George Froehlich - Fwd: 4 Adams Street - Header Change??

Subject: 4 Adams Street - Header Change??

You guys recently did structural plans for Matthew Mulkern at 4 Adams Street on Peaks Island.

3 SECOND FLOOR PLAN
scale : 1/4" = 1'-0"

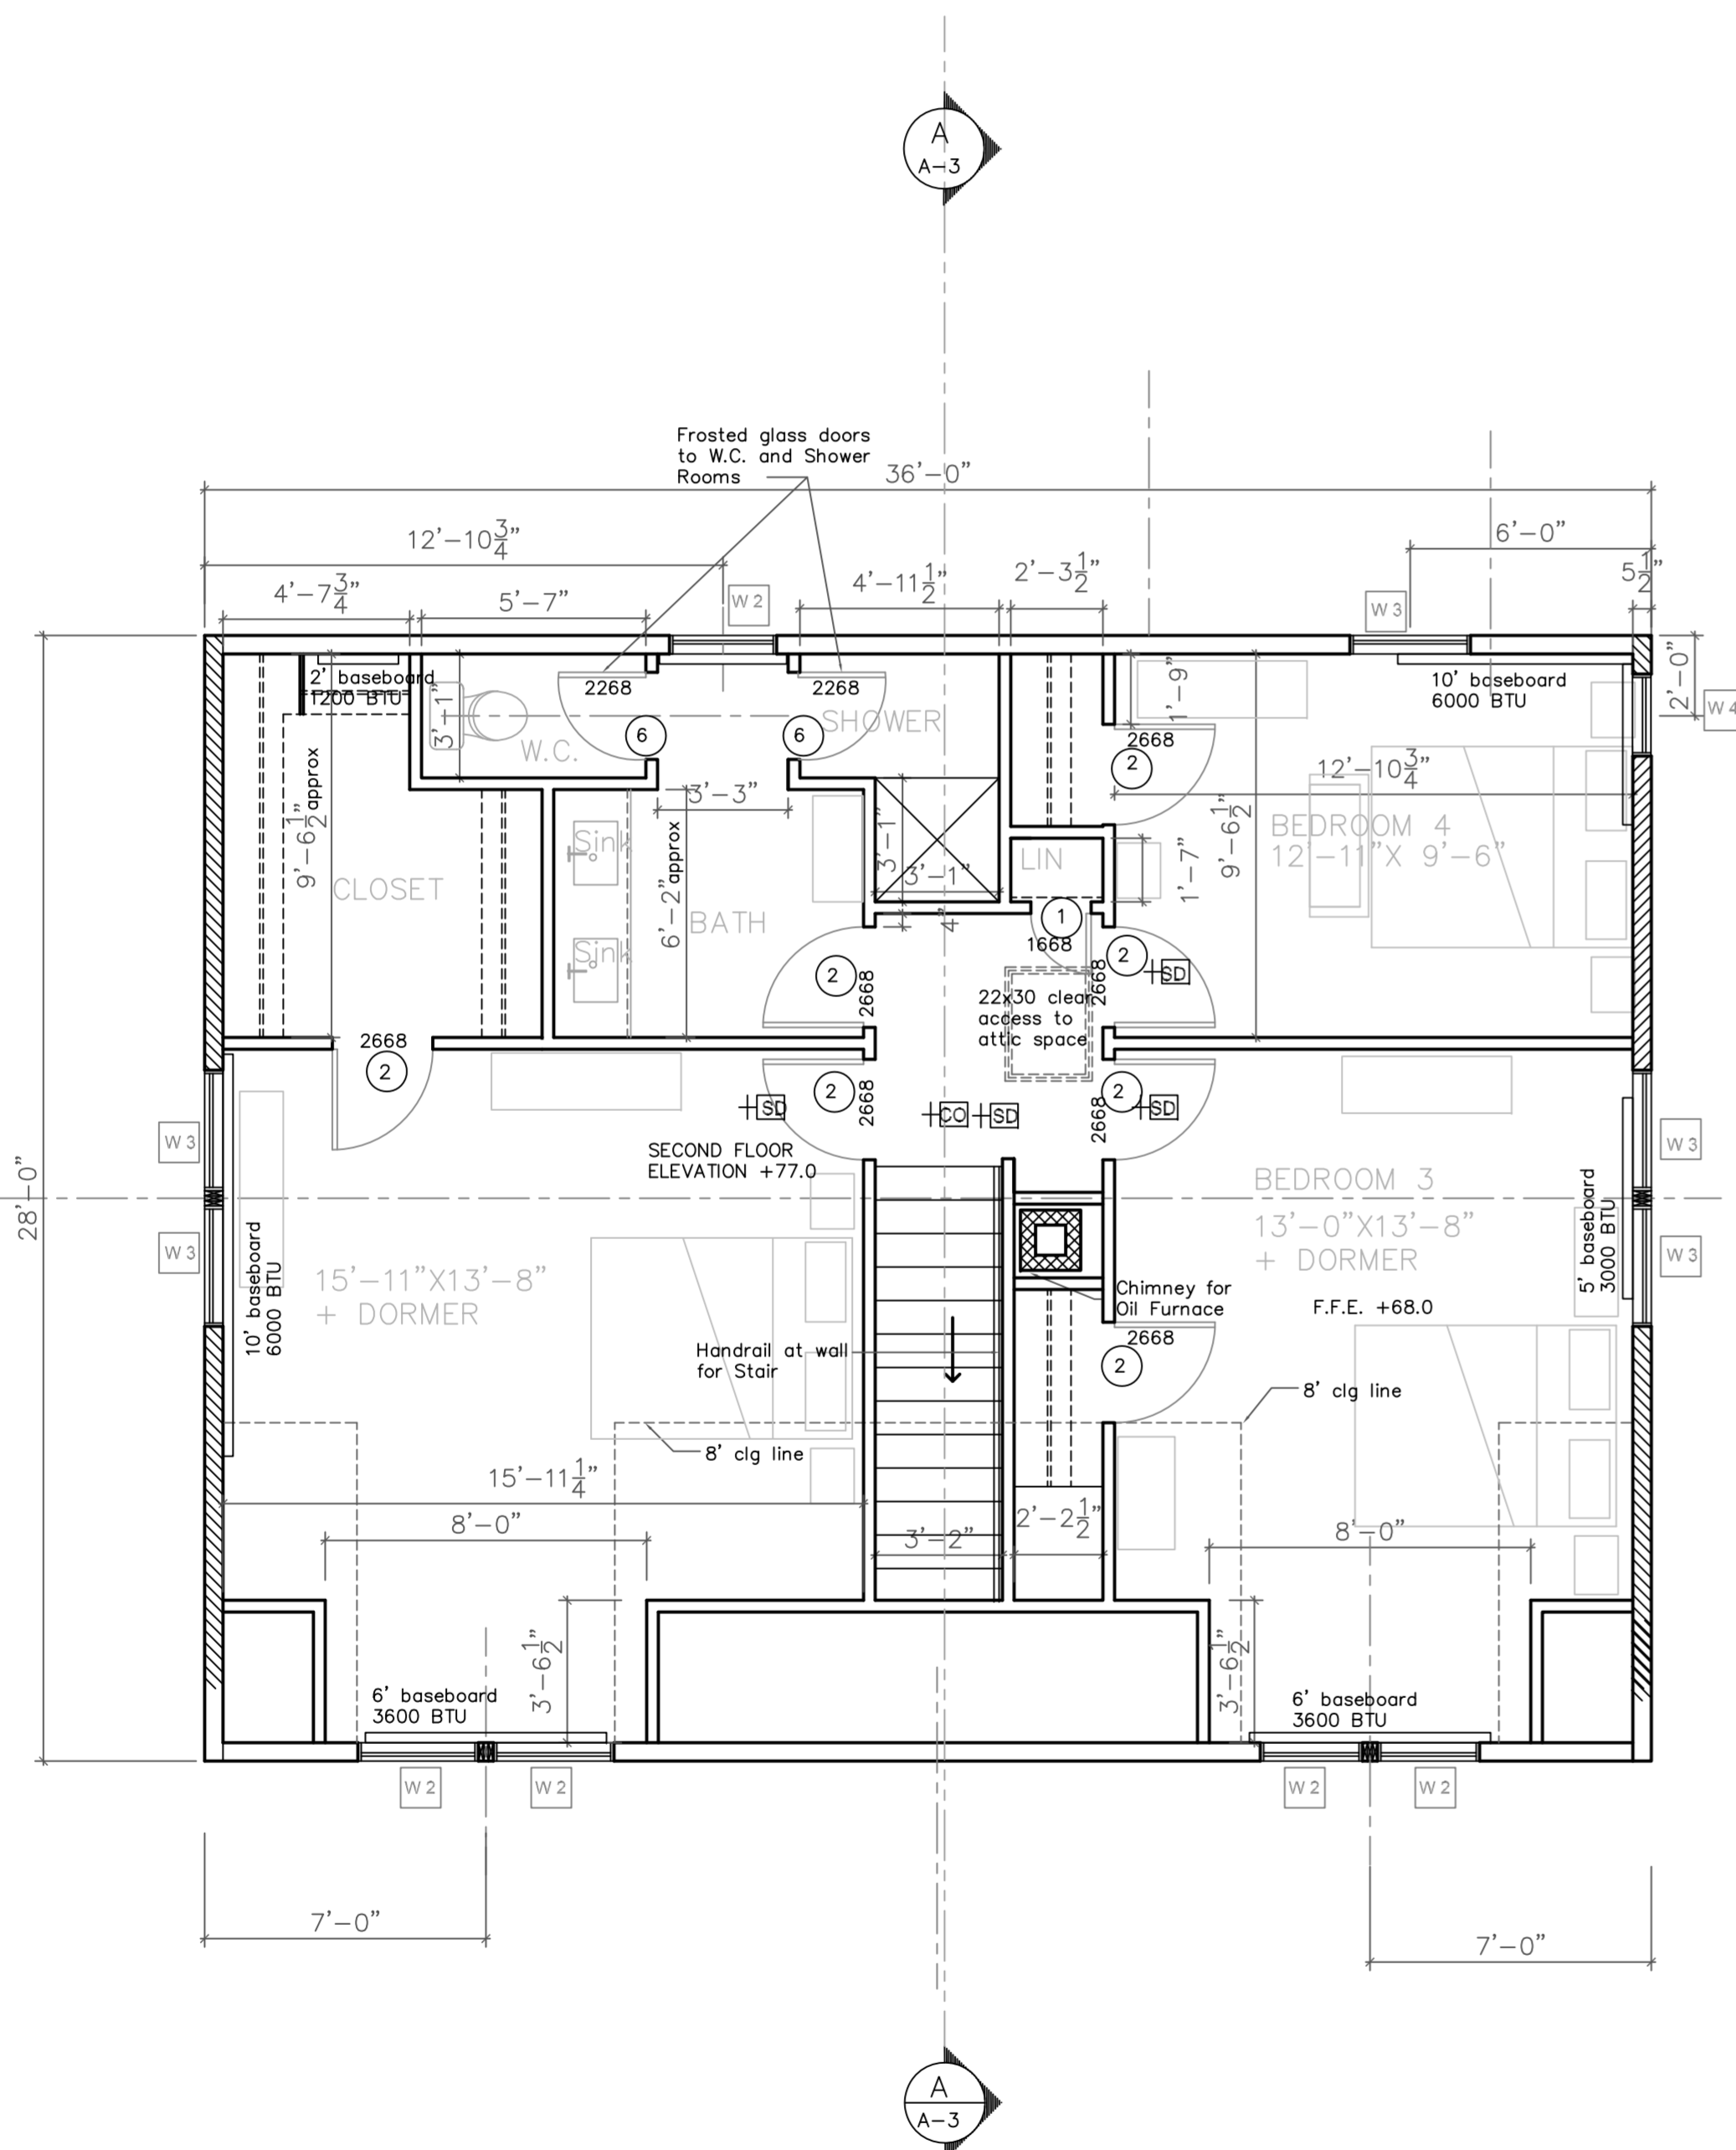
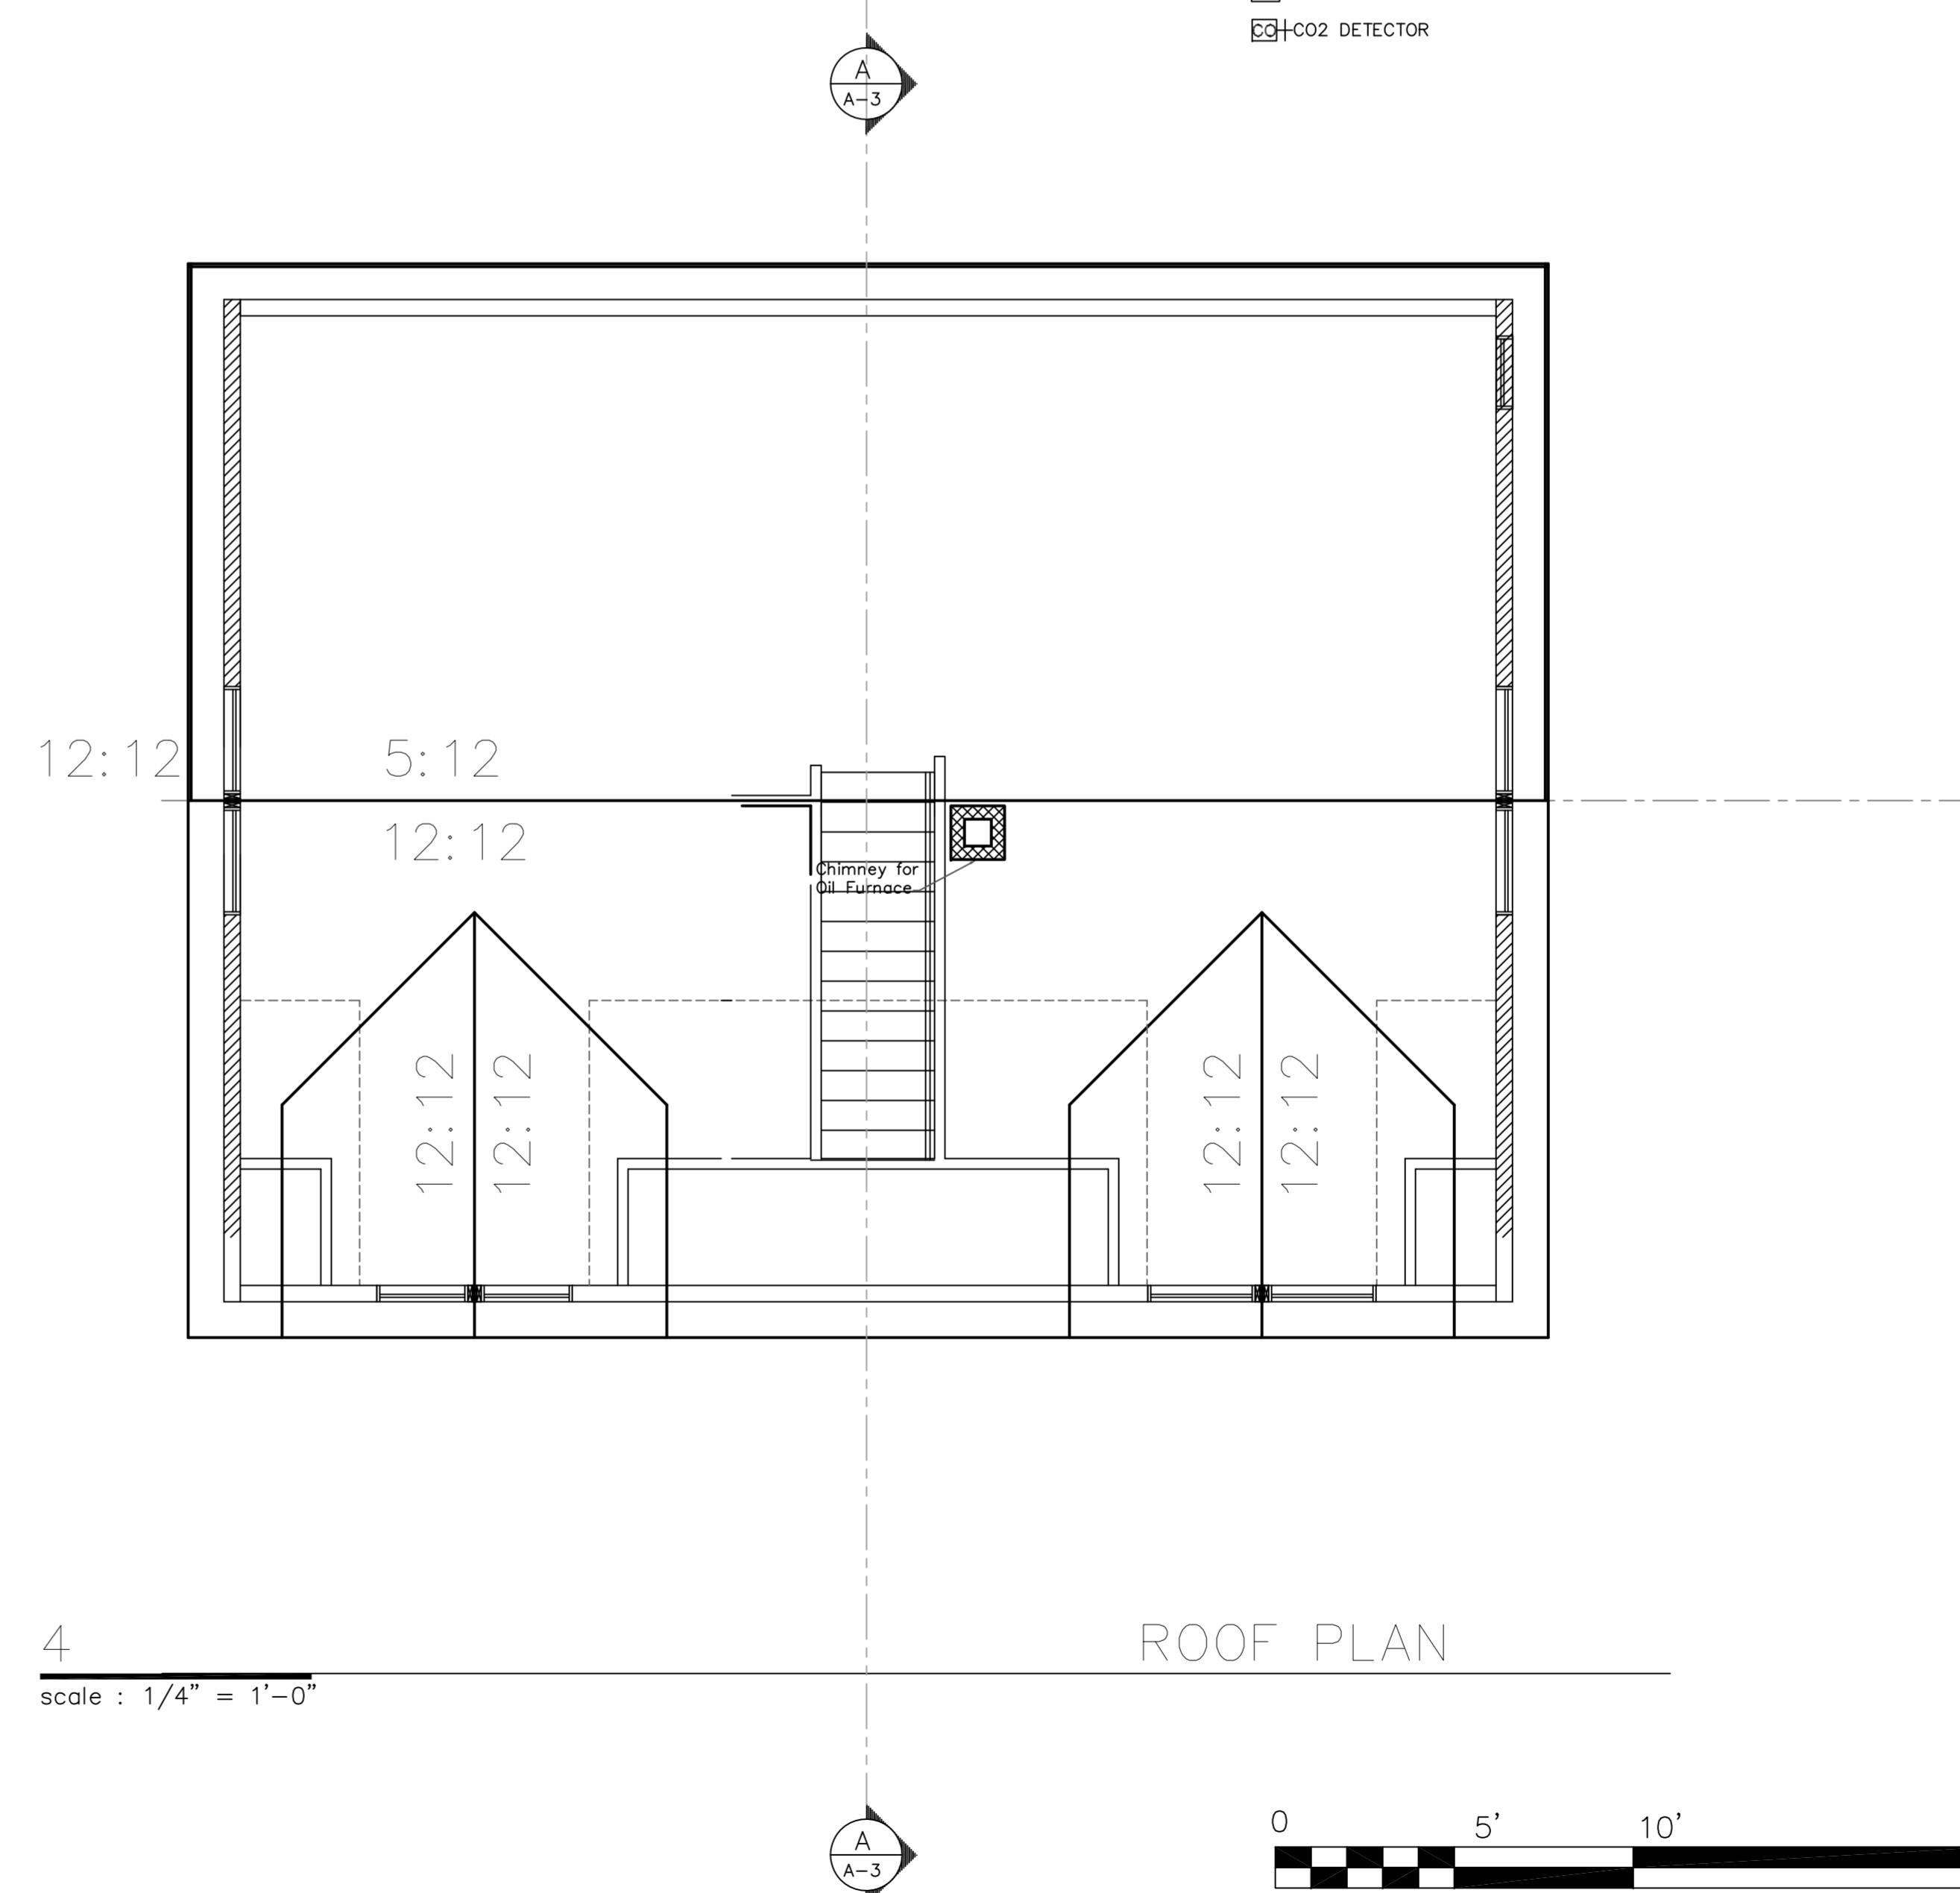
The architect, Jim Greenwell, has changed the design of the second floor and has changed a bedroom window from a single to a mullion. Our contractor would like to install a triple 2x10 with 1/2" CDX plywood headers above the four double windows (30410-2) - one the in the living room, one in bedroom #1, bedroom #2 and bedroom #3 . In the two front small gables and the first floor bathroom (window size is actually 36.5" wide R/O, not the 30" that is on the print), he wants to use triple 2x8 with 1/2" CDX headers. I assume that this is okay because it should increase the size of the headers you've already stamped off on, but I wanted to be sure this is acceptable.

The architect, Jim Greenwell, has changed the design of the second floor and has changed a bedroom window from a single to a mullion. Our contractor would like to install a triple 2x10 with 1/2" CDX plywood headers above the four double windows (30410-2) - one the in the living room (yes), one in bedroom #1 (yes), bedroom #2 (yes) and bedroom #3 (yes) . In the two front small gables and the first floor bathroom (window size is actually 36.5" wide R/O, not the 30" that is on the print), he wants to use triple 2x8 with 1/2" CDX headers. I assume that this is okay because it should increase the size of the headers you've already stamped off on, but I wanted to be sure this is acceptable. (yes)

This all seems fine and works for us. Let me know if you need anything else.
